Your Ref :
Our Ref : BR/243/14/NMA

Application for a non-material amendment following a grant of planning permission BR/286/10 for change in roof design above the garage including squaring off diagonal piers & amended first floor window, use of sand weatherboarding on extension and dwelling..
29 Hillsboro Road, Bognor Regis, ,

PROPOSED ELEVATIONS

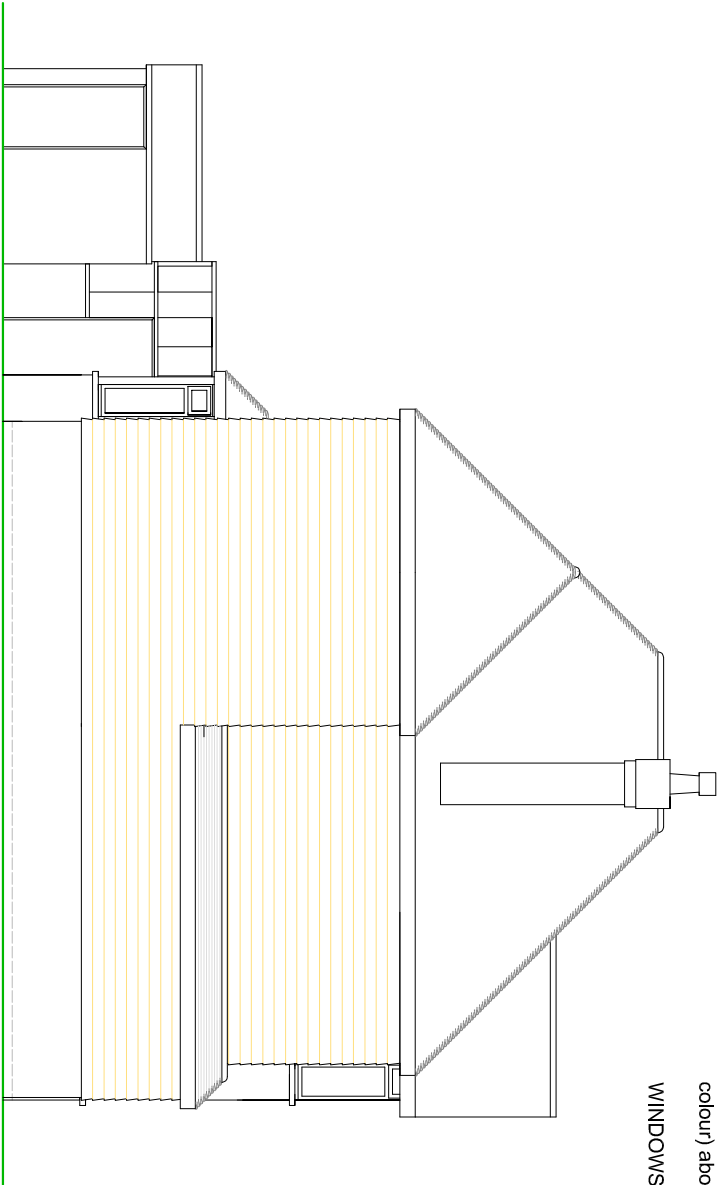
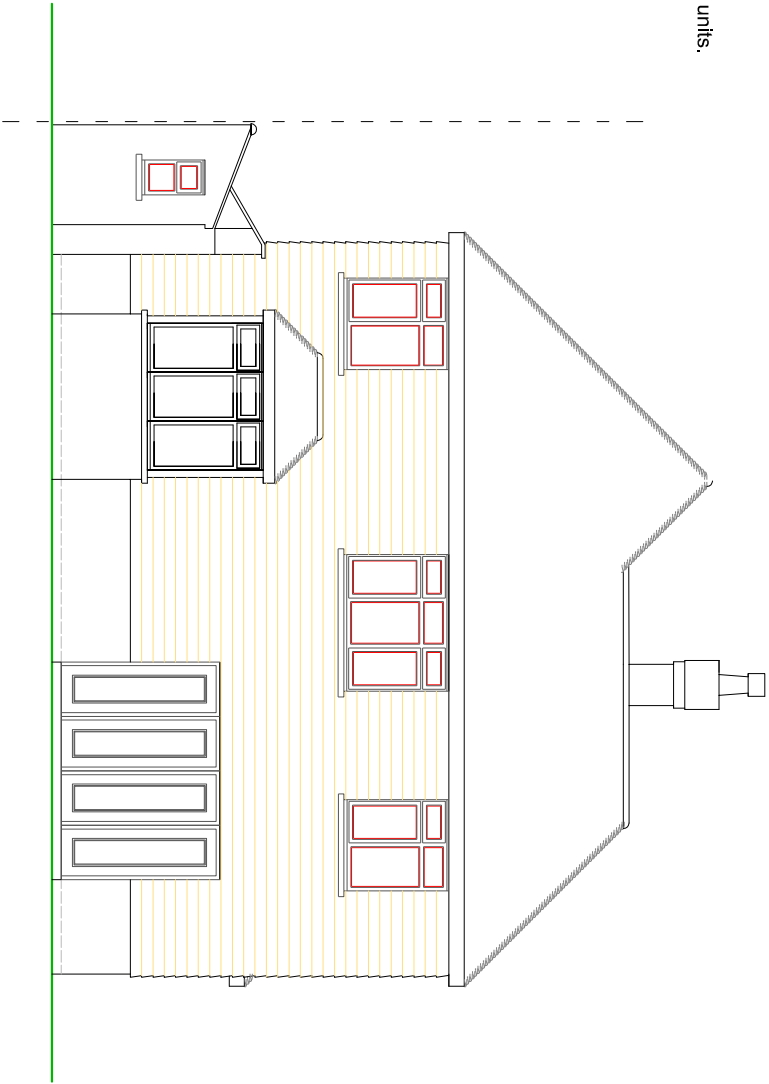
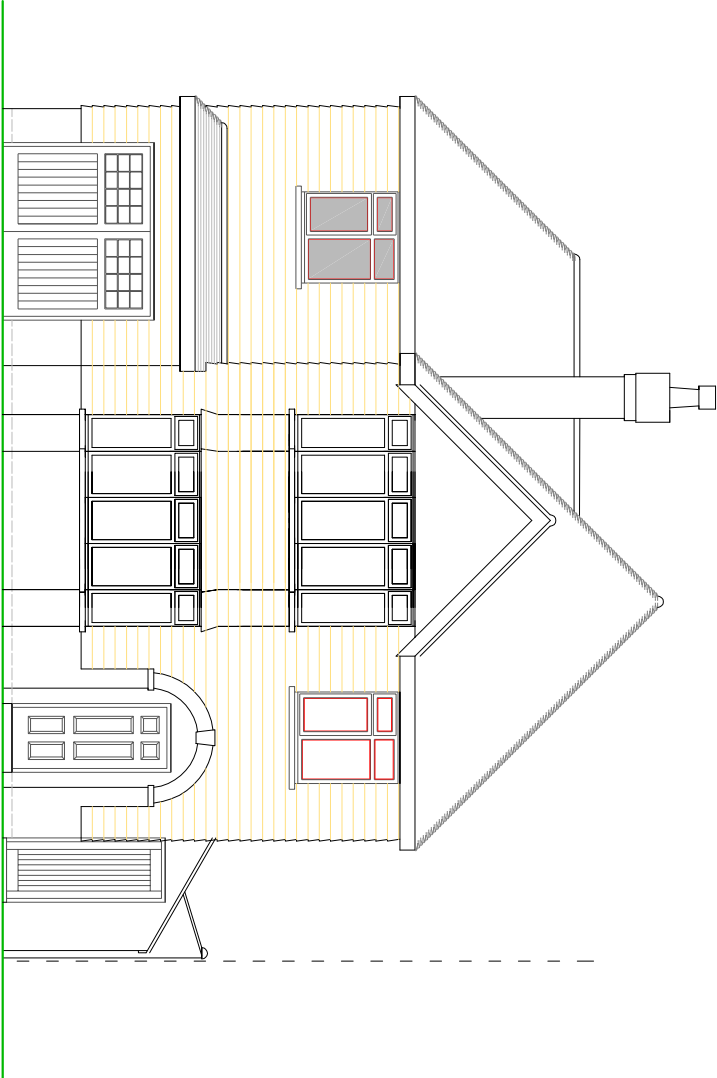
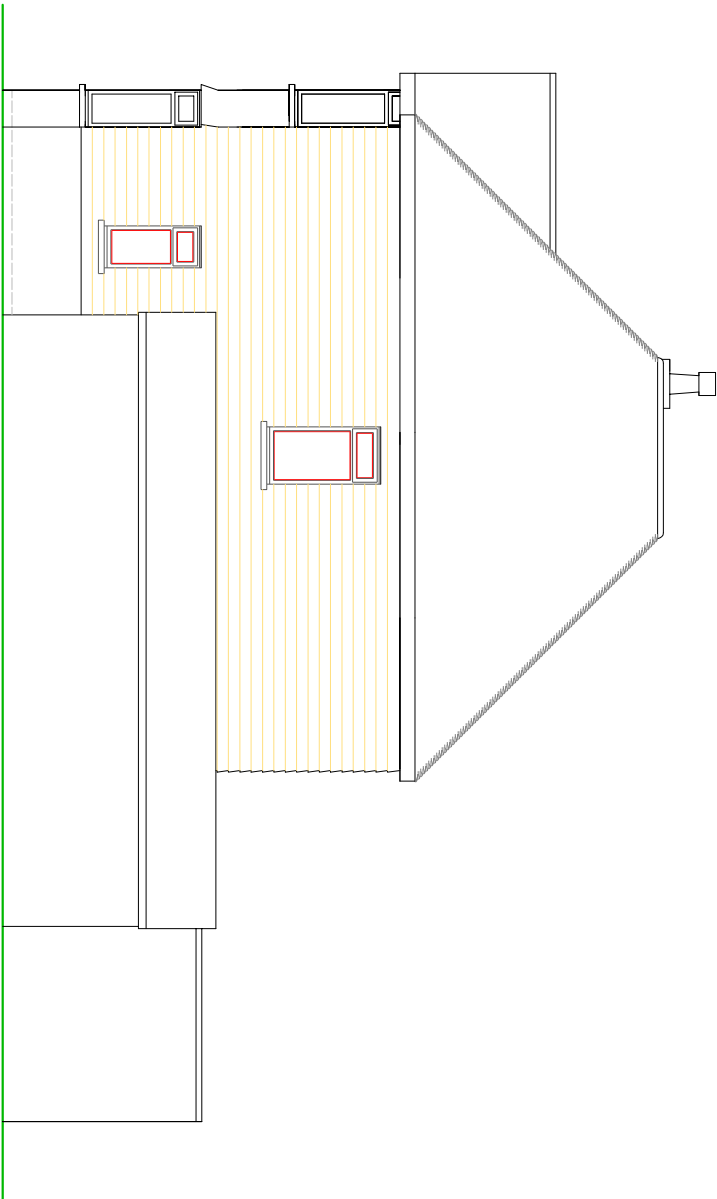
The alterations to the roof design above the garage with amended window detail at first floor level on the front elevation of the extension and the use of sand weatherboarding with painted render on the extension to match the host dwelling can be accepted as a non-material amendment.

The submitted Proposed Elevations 1:100 Drawing Rev A dated 6th October 2014 now becomes the approved plan for planning approval BR/286/10.
